Appeal Decision

Appeal Ref: APP/Z4718/W/24/3354853

Hall Ing Quarry, Hall Ing Road, Brockholes, Holmfirth, HD3 3FR

- The appeal is made under section 78 of the Town and Country Planning Act 1990 (as amended) against a refusal to grant planning permission.
 - The appeal is made by Mr S Morris against the decision of Kirklees Council.
 - The application Ref is 2024/62/90416/W .
 - The development proposed is the erection of single dwelling.
-

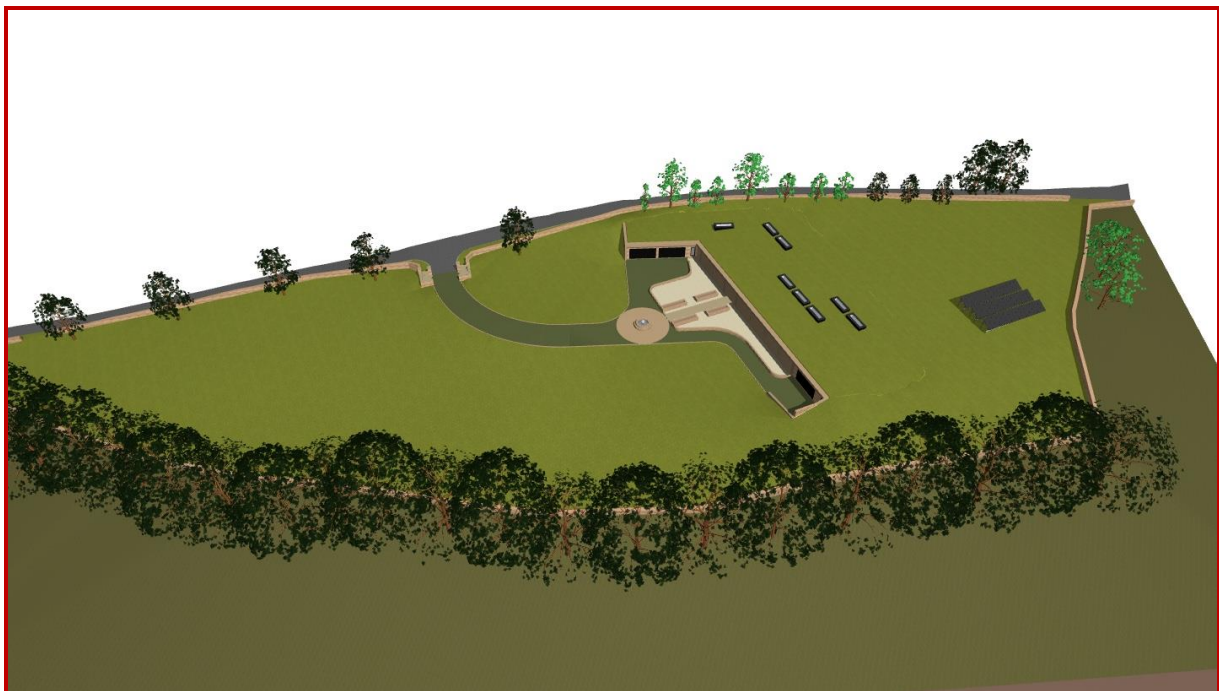
32. The dwelling would sit as a single-storey structure within excavated ground at the base of the quarry, with its rear elevation positioned close to the quarry face and the roof largely covered in soil and grass, leaving only one exposed elevation. This approach misses any meaningful response to the dramatic changes in level across the site and does not exploit the potential for a sectionally expressive design. The proposal fails to capitalise on the site's topography, which presents clear opportunities to inform and inspire a more distinctive and responsive design.

33. The appellant characterises the proposal as a modern building that takes advantage of an existing man-made landscape. However, the house would be buried in front of the quarry face, which is one of the site's most striking and defining geological features. There is no interplay between the building and the rock face, no sectional or spatial dialogue with its dramatic backdrop, and no reference to the site's quarrying history. The design gives no sense of inhabiting a place defined by a powerful geological setting; instead, the quarry is effectively sidelined rather than recognised.

34. The detailing of the proposal does little to elevate the design. The form and arrangement of openings and rooflights are ordinary and commonplace, showing no particular refinement or innovation. The immediate setting of the house, including the turning area, manoeuvring space, drive, and access to an array of industrial-scaled openings, would appear incongruous and strikingly mundane when set against the wider, scenic, and bucolic landscape.
